Application Ref:	2025/0668			 Ribble Valley Borough Council www.ribblevalley.gov.uk
Date Inspected:	Pre-App	Site Notice:	N/A	
Officer:	Stephen Kilmartin			
DELEGATED ITEM FILE REPORT:				REFUSAL

Development Description:	Proposed full repair and conversion of the existing Field Barn to make a dwelling house within the linked farmhouse cluster at Alder House Farm.
Site Address/Location:	Alder House Holden Lane Bolton by Bowland BB7 4LZ

DRAWING
Expanded Proposed Site Plan

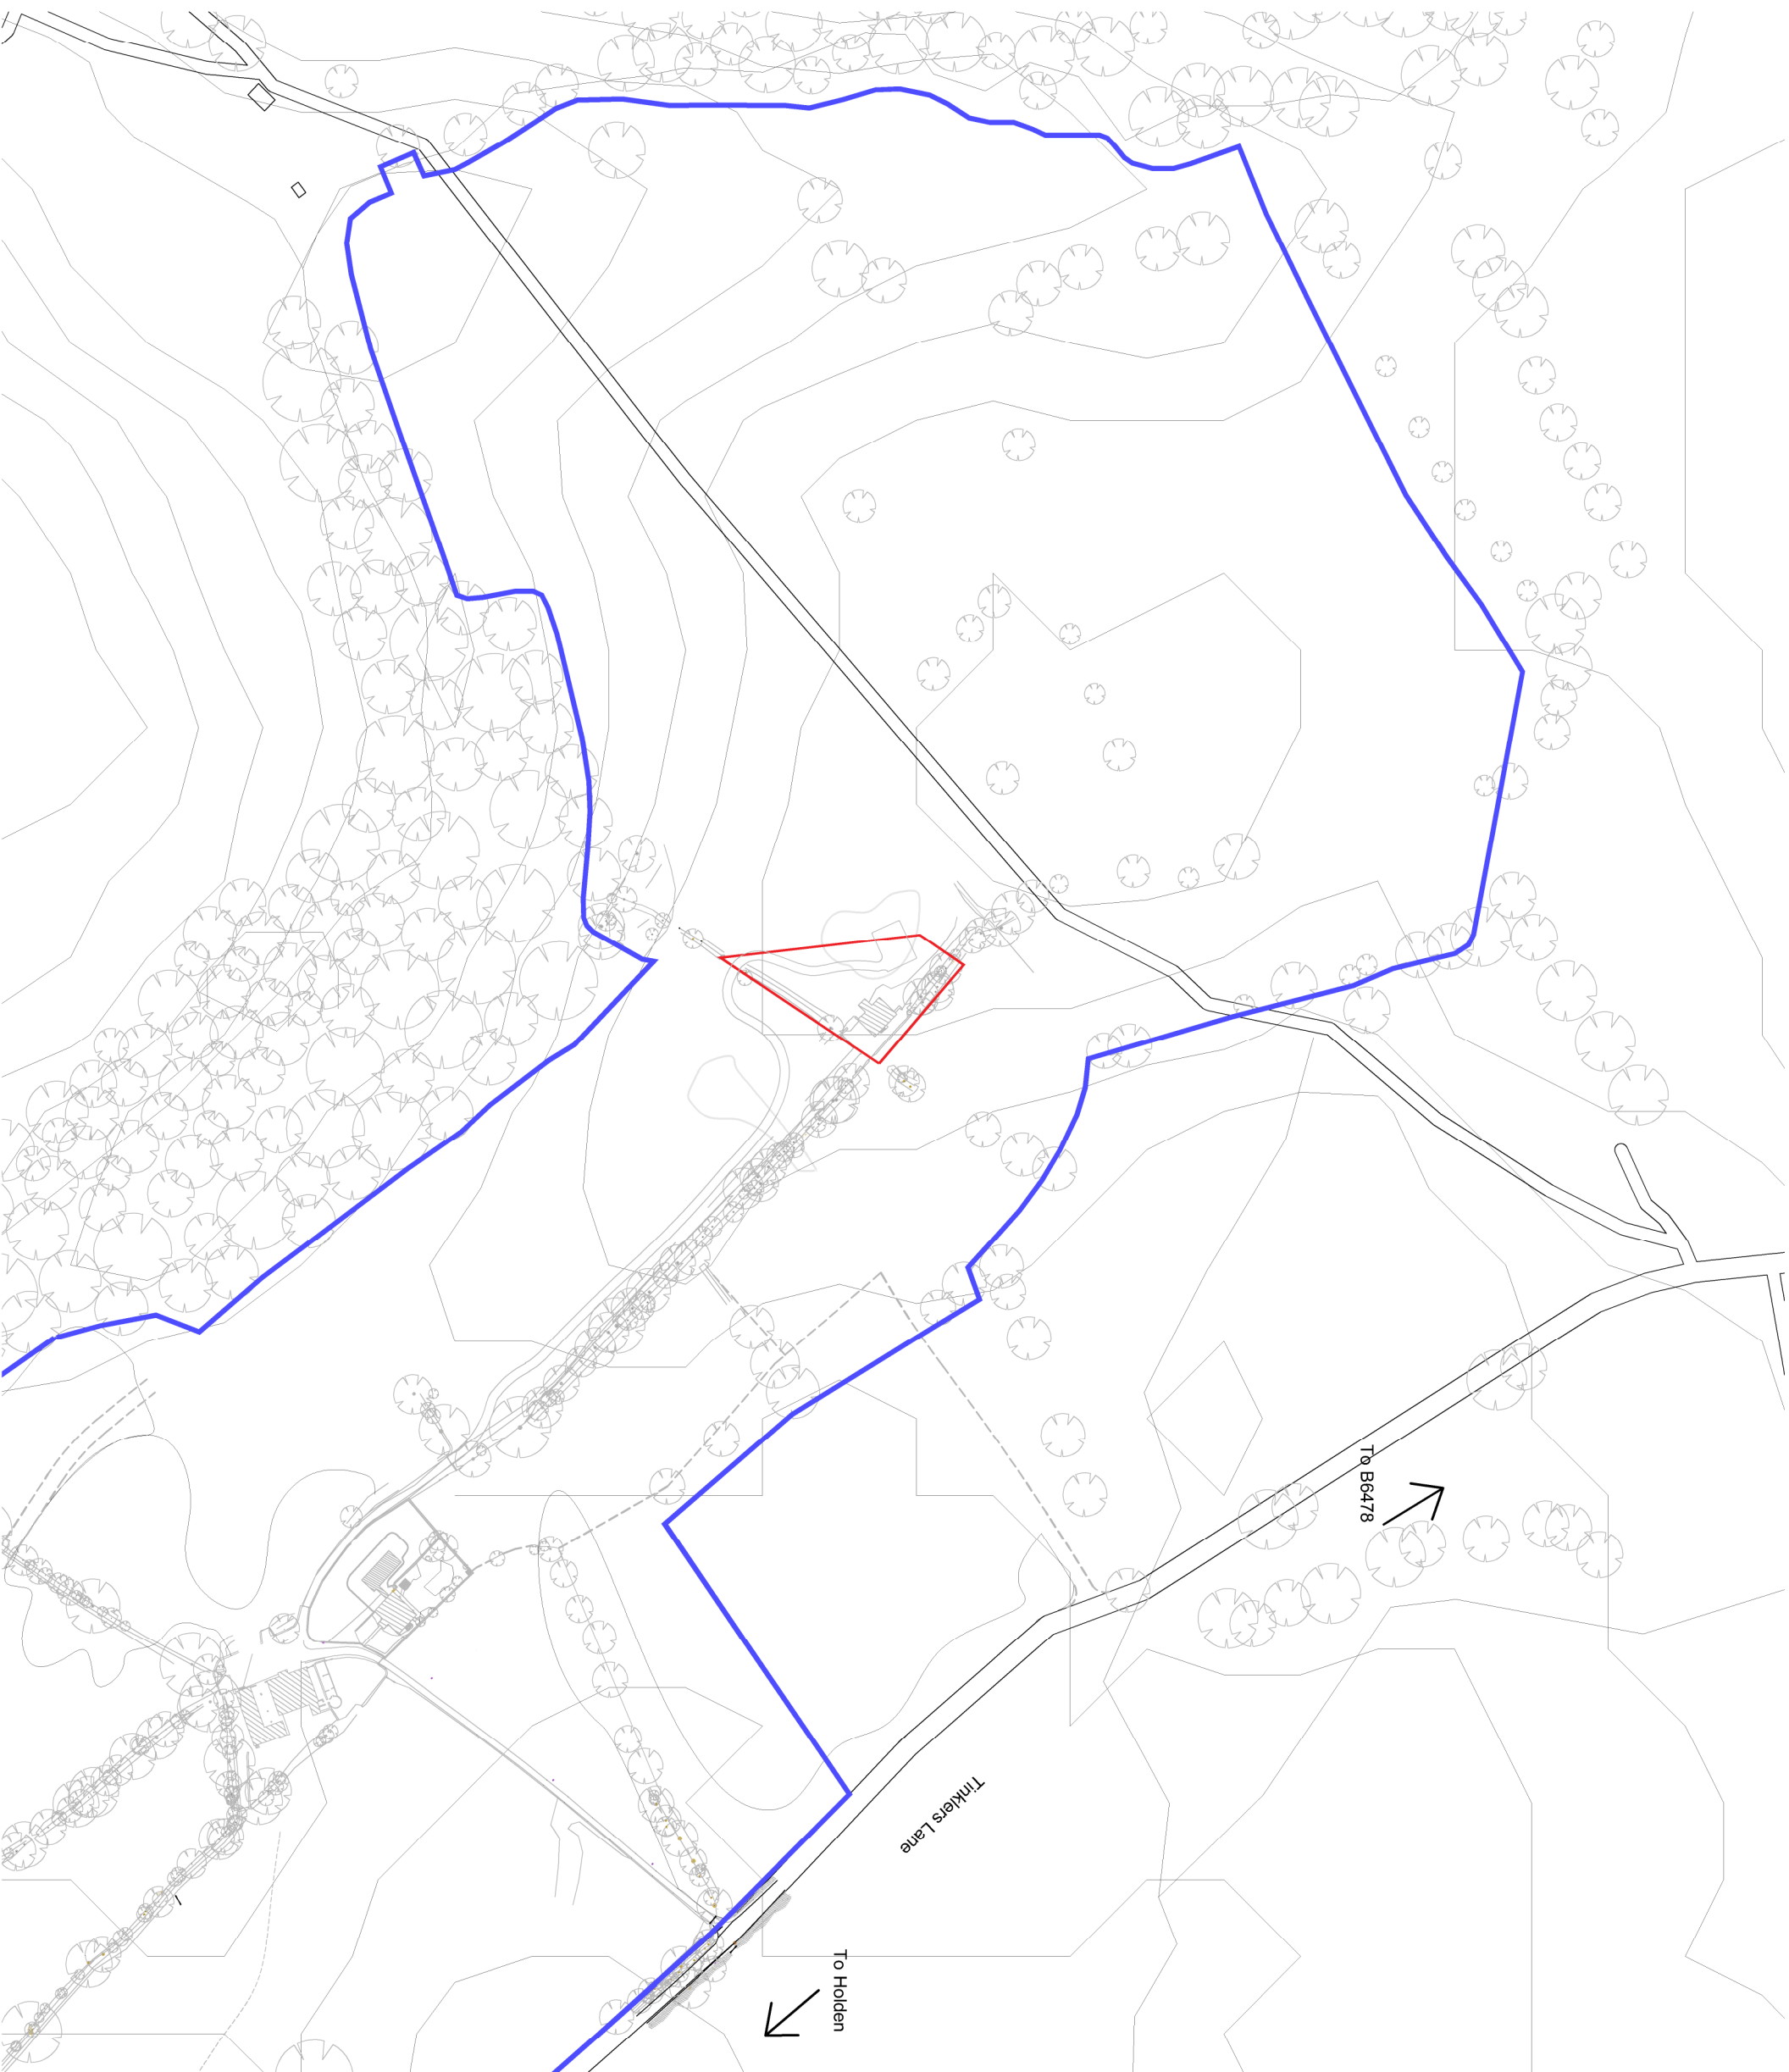
However, in respect of the proposed access track, it is proposed that the track will interface with the existing track that serves 'Alder house' to the south-east, with the extents of new track proposed measuring approximately 370m in length.

Whilst it is noted that there is an existing track off Holden Lane serving Alder House, the extents of the new track proposed, including the extents of its visual incursion into at present untouched greenfield agricultural land, would result in the introduction of an incongruous form of development that would result in the visual suburbanisation of the landscape character of the area. Being of significant detriment of the character, appearance and visual amenities of the Forest of Bowland National Landscape, contrary to Key Statement EN2 and Policies DMG1 and DMG2 of the Ribble Valley Core Strategy.

The location plans for both the proposals (25/0668 and 25/0667) also do not include the access track within the red edge, which needs to be included up to the adopted highway line. Given that these proposals will result in an increase in dwellings along the private access track, please can a detailed site access plan for the junction with Holden Lane be provided along with a detailed access track drawing, showing any existing passing places along its length.

However, the submitted details propose the creation of an 'informal car-parking area via the 'cutting-in' to the land to the north-west of the application building. With it further being proposed that a vehicular access track, for a length of approximately 370m will be created to facilitate access to the building upon

its conversion. With the cumulative area of non-priority habitat being impacted as a result of the proposal, significantly exceeding the 25 Sqm de-minimis threshold.

03: The proposal, by virtue of the extents of the proposed vehicular access track, would result in the introduction of an incongruous form of development that would result in the visual suburbanisation of the landscape character of the area. Being of significant detriment of the character, appearance and visual amenities of the Forest of Bowland National Landscape, contrary to Key Statement EN2 and Policies DMG1 and DMG2 of the Ribble Valley Core Strategy.

A detailed parking plan showing at least 3 parking spaces, measured 2.4m wide and 5m long. Where they are adjacent to a fence or similar obstruction an additional width of 0.6m should be provided and if the driveway/parking area has shared pedestrian access an additional 0.8m should be provided.

Clear turning provisions, given the need to enter and exit in a forward gear to ensure there is no reversing on Holden Lane and remove any conflict on the private access track.

An amended location plan including the access track up to where it meets the adopted highway. A detailed drawing of the access track, showing the width and any existing passing places along its length to ensure minimal conflict on the private track and prevent any reversing back to the access point with Holden Lane.

A detailed site access drawing – to ensure it is an appropriate width and length to support access to 3 dwellings and remove any conflict occurring on Holden Lane.
